PRE-DEVELOPMENT APPLICATION COMMENTS

APPLICATION NO:	PRE0078/22																																																														
ADDRESS:	Archdale Walk (Coonanbarra Road Wahroonga) - Location of works that form part of this Pre-DA Sites below associated with the proposed works: 4-10 Neringah Avenue Sth WAHROONGA NSW 2076 12 Neringah Avenue Sth WAHROONGA NSW 2076																																																														
DESCRIPTION OF PROPOSAL:	Request for advice in relation to the re-grading of a footpath known as Archdale Walk. The works are associated with a proposed SSD for a seniors living development at 4-12 Neringah Avenue South, Wahroonga.																																																														
MEETING DATE	10 August 2022																																																														
PRESENT AT MEETING:	<table border="1" style="width: 100%;"> <thead> <tr> <th colspan="3"><i>Council</i></th> </tr> <tr> <th><i>Name</i></th><th colspan="2"><i>Title</i></th> </tr> </thead> <tbody> <tr> <td>Jonathan Goodwill</td><td colspan="2">Team Leader Development Assessment Central</td> </tr> <tr> <td>Haroula Michael</td><td colspan="2">Executive Assessment Officer</td> </tr> <tr> <td

Post Office Ramp Alignment - Plan

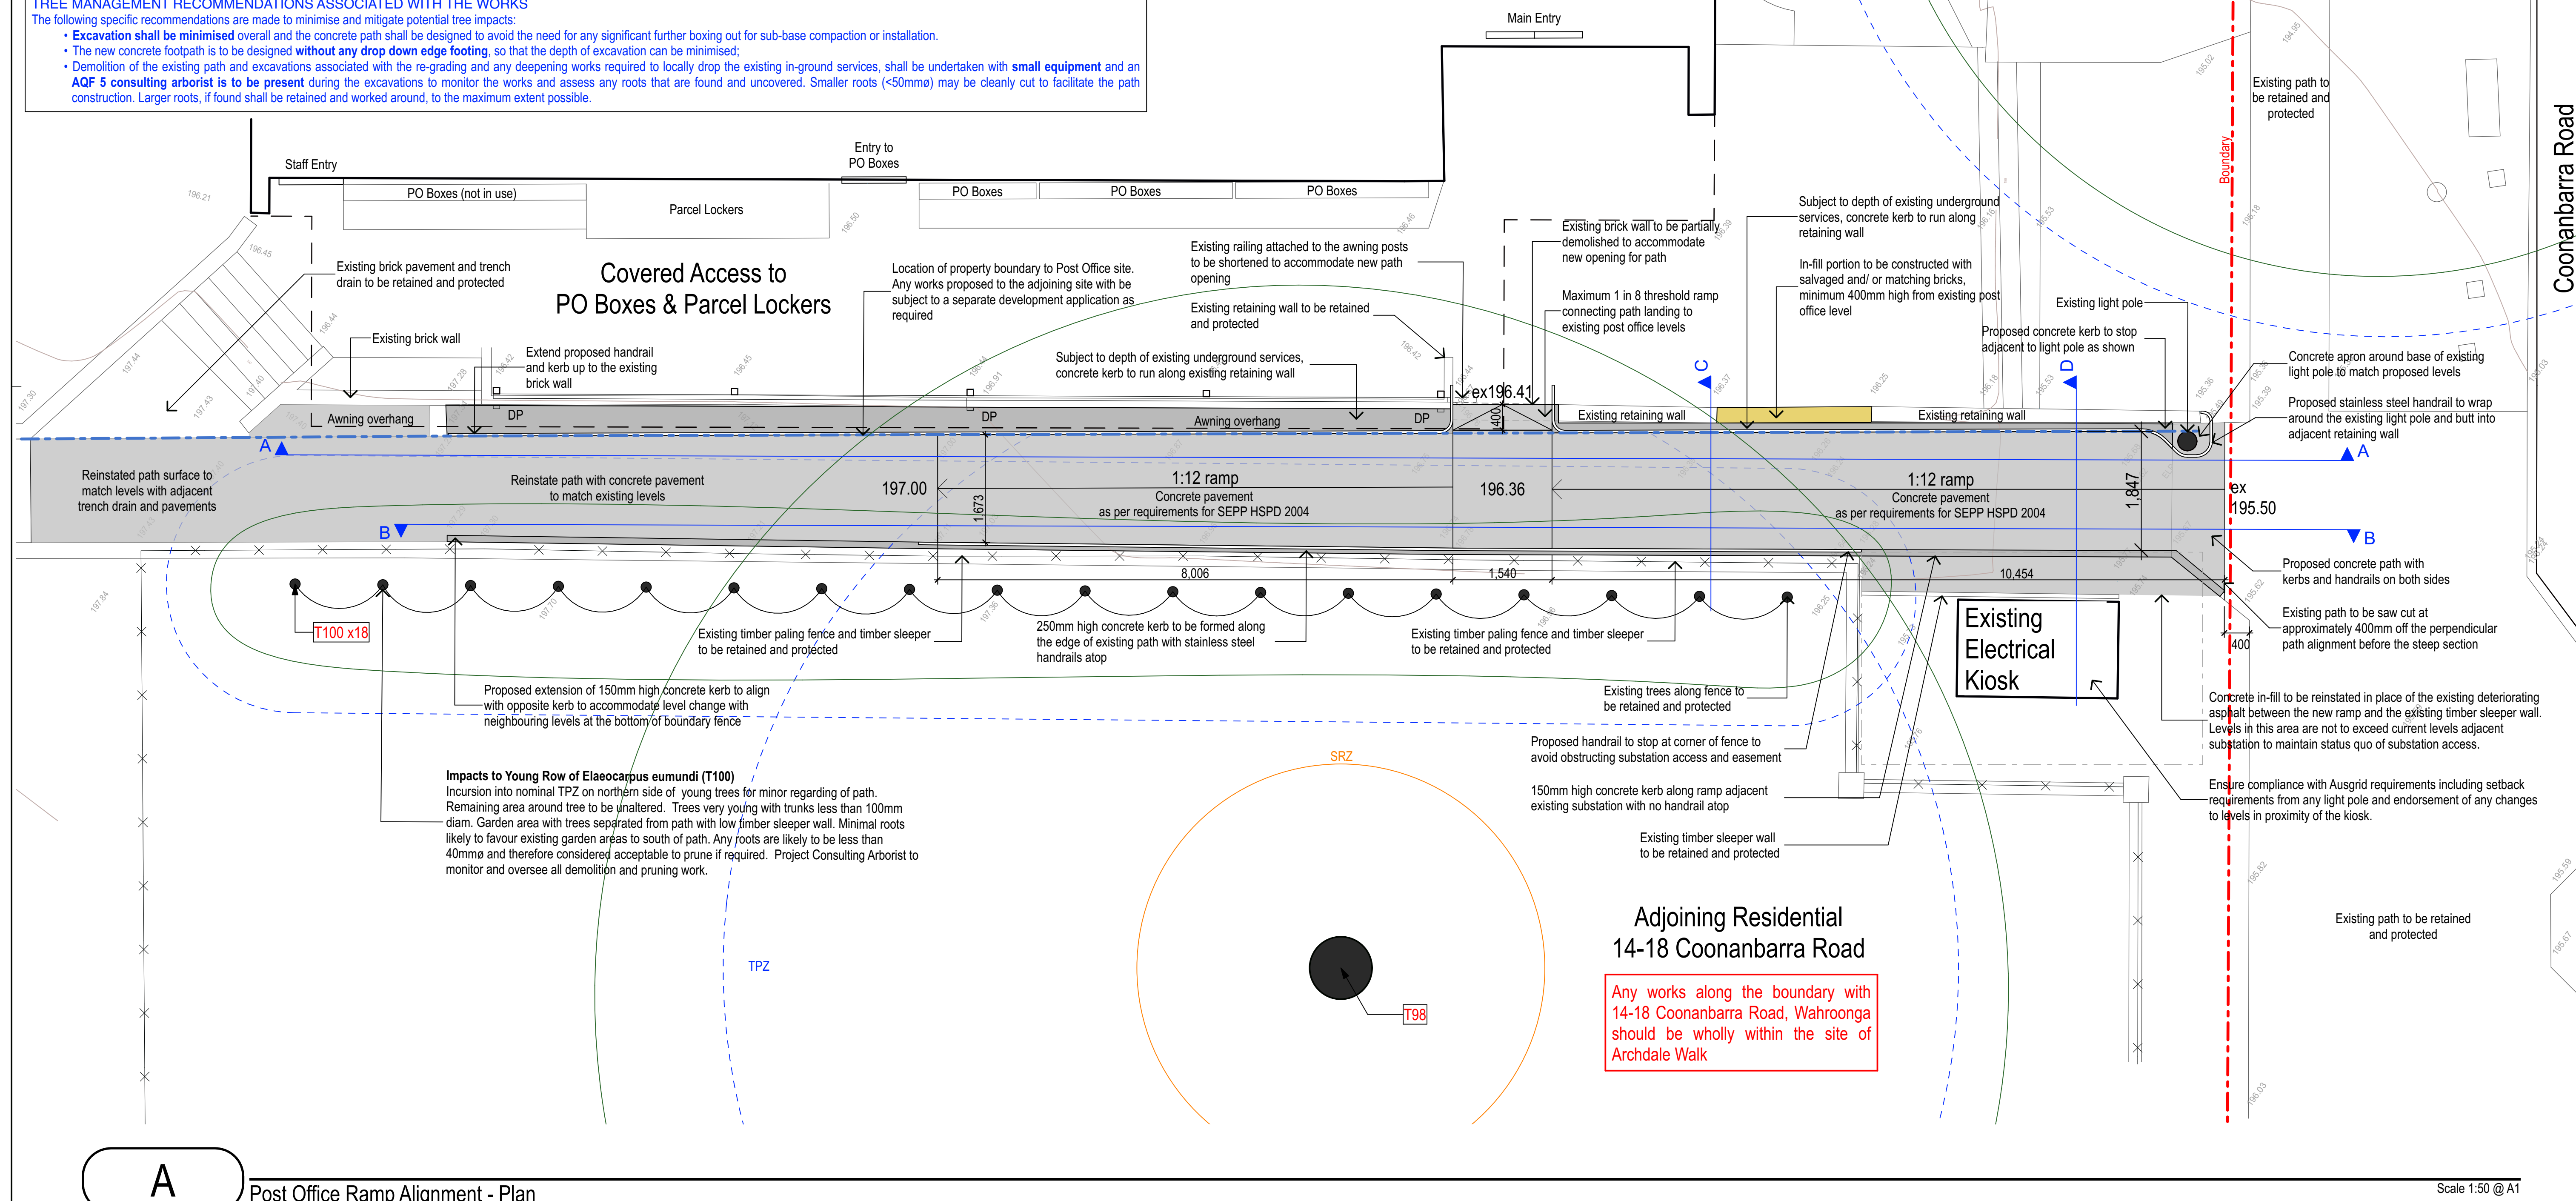
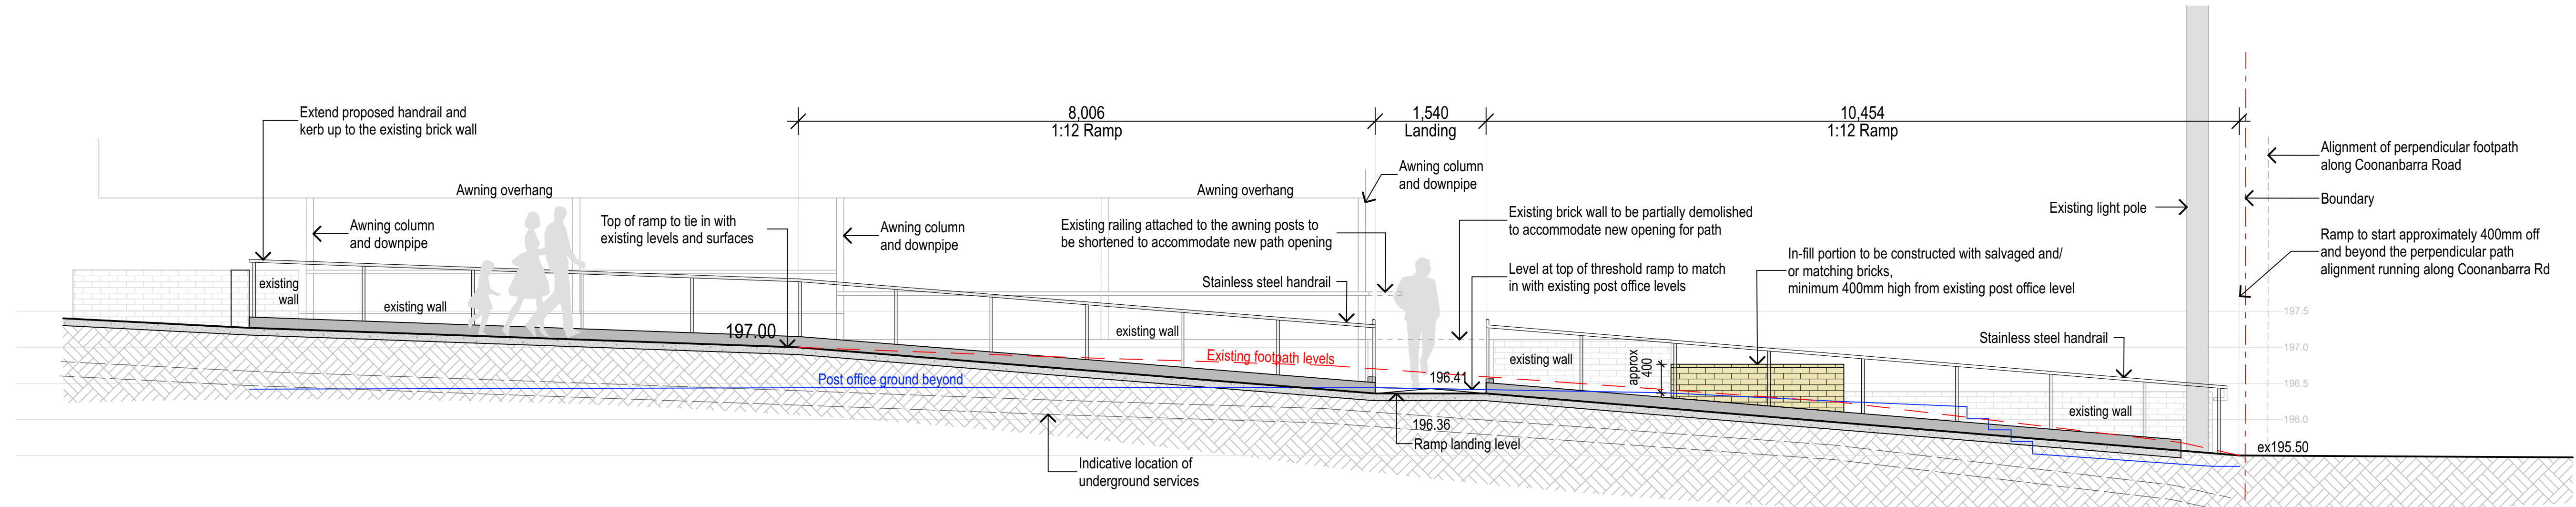
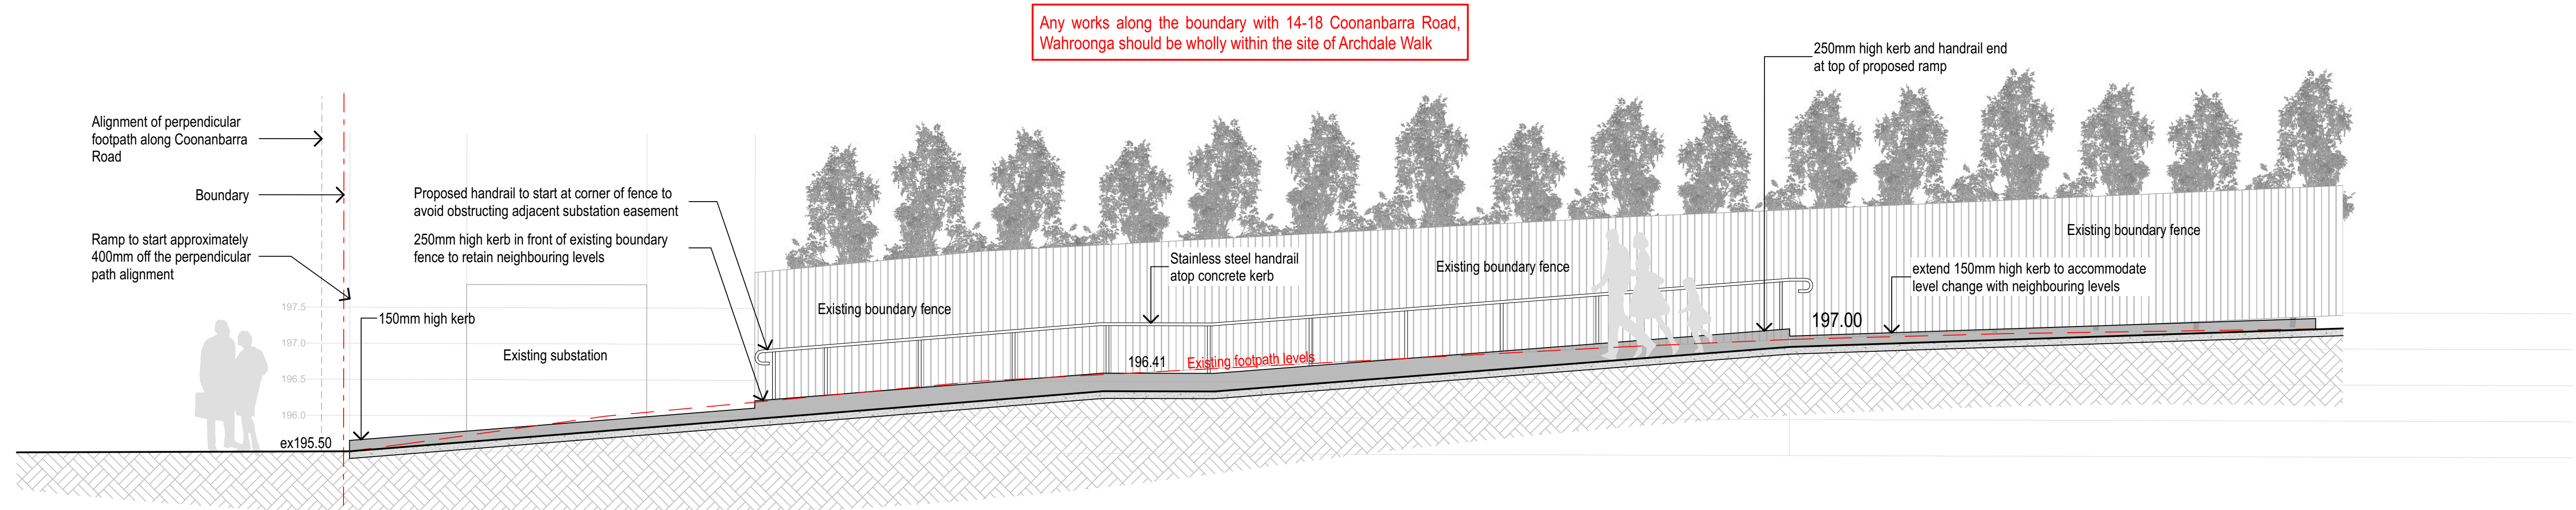
- The footpath remediation works to be generally in accordance with Drawing No. LA-DG-80-A0/A and LA-DG-81/A' prepared by Arterra Design Pty Ltd.
- The location of all underground services as well as drainage, including levels and any adjustments to existing underground services are to be shown for setting out for construction.

- The access consultant must endorse the plans to ensure compliance with the accessible walkway, ramps and landings under AS1428.1-2009.
- Any detail design will need to account for the roof water drainage for the post office which is currently under the path.

- In regard to the brick wall along the post office boundary, where the existing gap in the brick wall is to be filled, the infill portion of the wall should be approx. mid height between the 2 existing walls. The new wall as shown in the drawings is a potential trip hazard from Post office path level.

- The laneway width should be as consistent as possible. The eastern section of the footpath should not have 2 levels as the "step" between the brick retaining wall and the new footpath appears to be 'leftover' land and is not a good design outcome. The new footpath level should continue right across laneway up to the brick retaining wall, unless it can be proven that services or subsurface conditions prohibit this from being possible. If is not possible, then another design solution must be explored. If it is possible, then the hand rail is to run along the edge of the path.

- The end of the hand rail should not extend into footpath area along Coonanbarra Road.
- A detail of the treatment between substation and new path levels, as well as details of changed levels is to be provided.
